**WELWYN HATFIELD BOROUGH COUNCIL  
EXECUTIVE DIRECTOR - PLANNING, PUBLIC PROTECTION AND GOVERNANCE**

**DELEGATED APPLICATION**

**Application No:** 6/2021/2600/HOUSE  
**Location:** 28 Thistle Drive Hatfield AL10 9FQ  
**Proposal:** Conversion of roof space to habitable use to include a front and rear dormer, 1 x skylight, and the erection of a single storey front, side and rear extension  
**Officer:** Ms Ashley Ransome

**Recommendation:** Refused

PROPOSED SITE PLAN
 scale 1:200

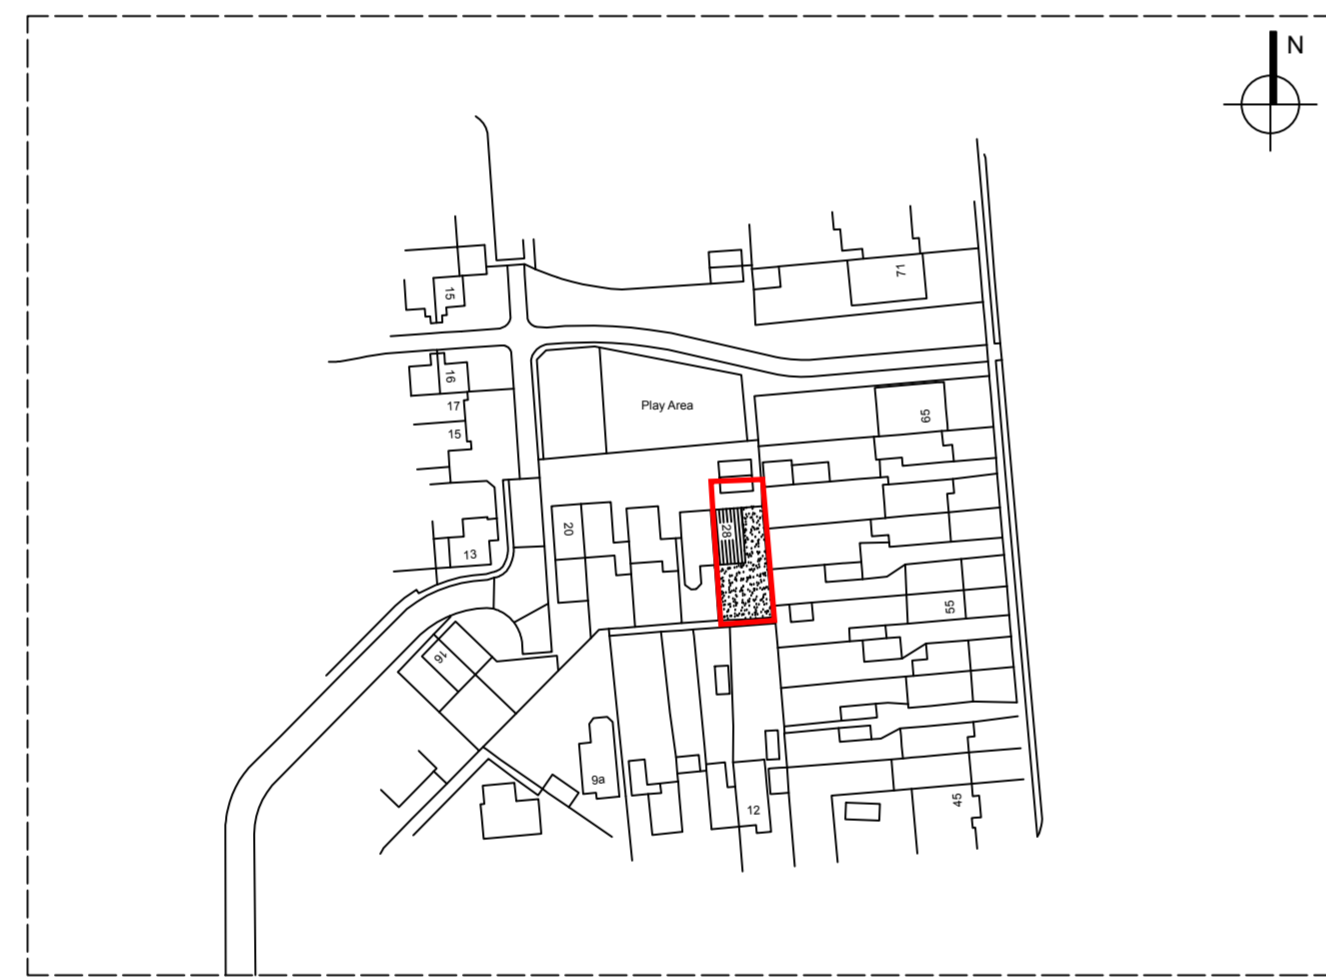
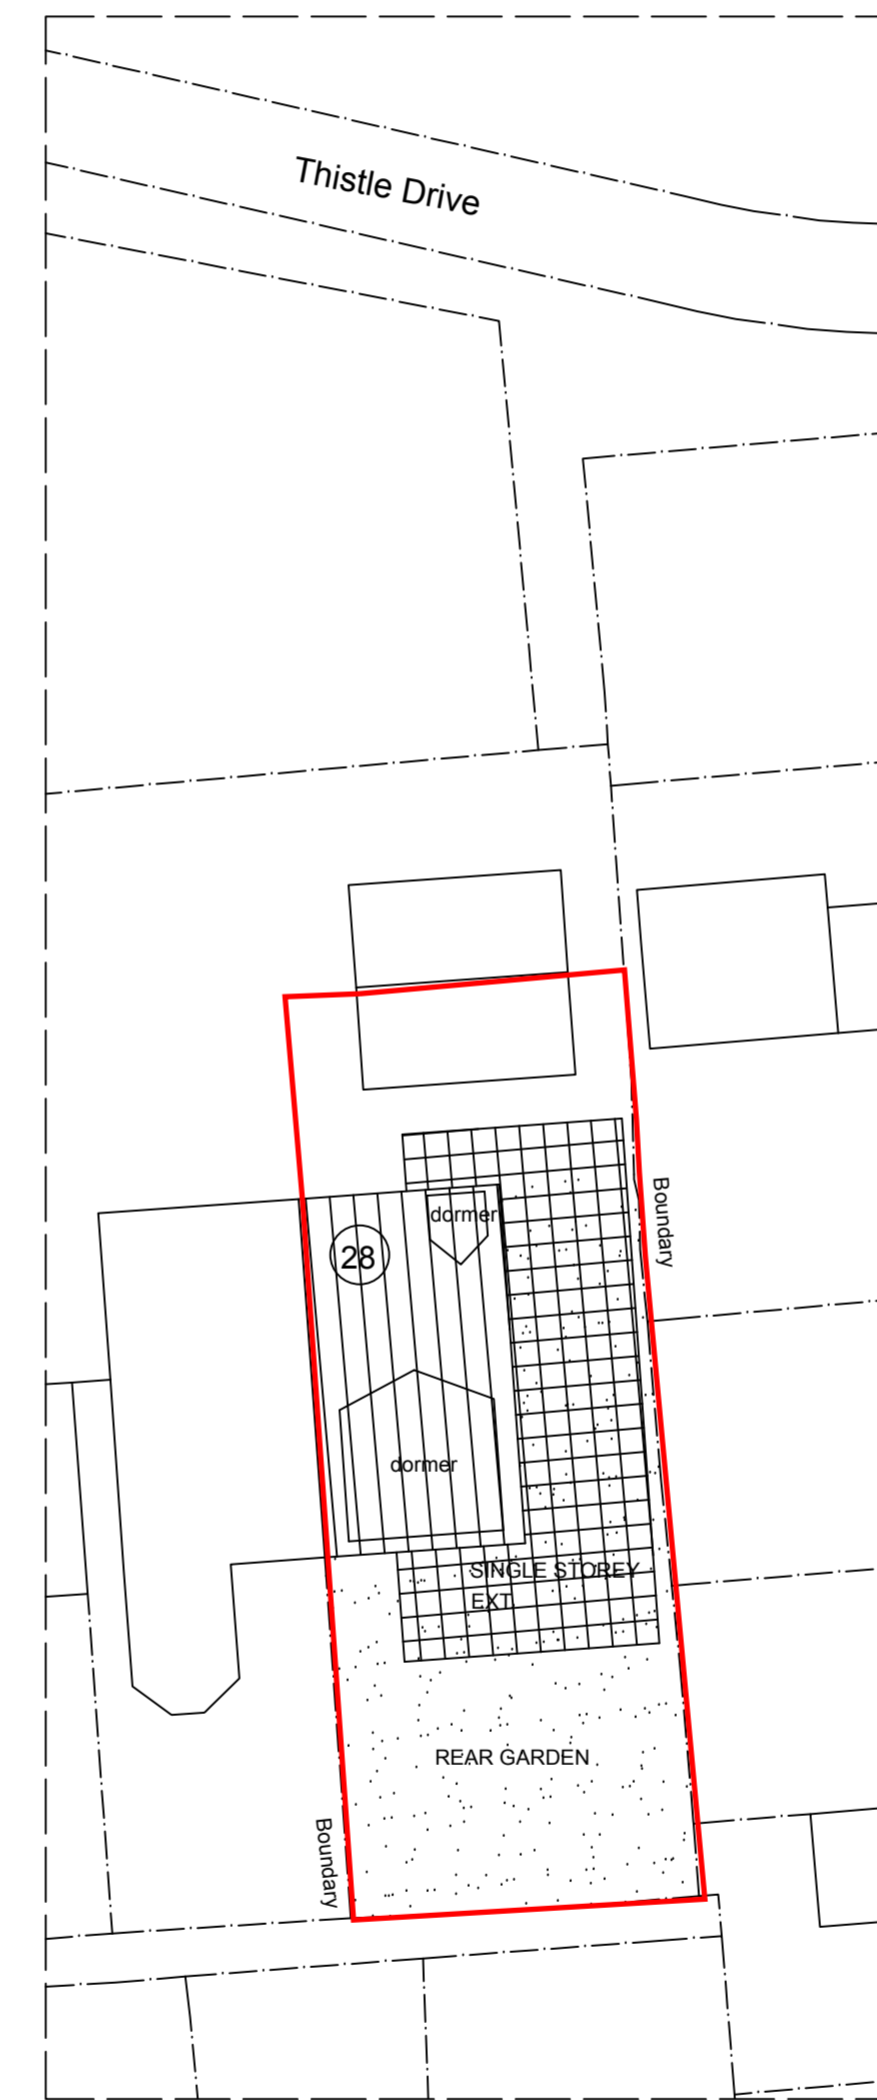
<p><b>Access, car parking and highway considerations</b></p>	<p>Policy M14 of the District Plan and the Parking Standards SPG use maximum standards that are not consistent with the Framework and are therefore afforded less weight. In light of this, the Council have produced an Interim Policy for Car Parking Standards that states that parking provision will be</p>

<p>assessed on a case-by-case basis and the existing maximum parking standards within the SPG should be taken as guidance only. This means that higher or lower car parking standards than those set out in the SPG can be proposed and determined on a case-by-case basis taking into account the relevant circumstances of the proposal, its size context and its wider surroundings.</p> <p>The proposal would increase the number of bedrooms from three to four. The Council's car parking guidance for a dwelling with four or more bedrooms in this location is three spaces per dwelling. It is unclear what off-street parking is available at the site, but it is unlikely that there would be provision for three spaces, thus there is an under provision of off-street parking provided. There is however unrestricted parking space for vehicles on the road opposite the application site and it is considered that the shortfall of parking is not sufficient to warrant a reason for refusal of this application.</p>
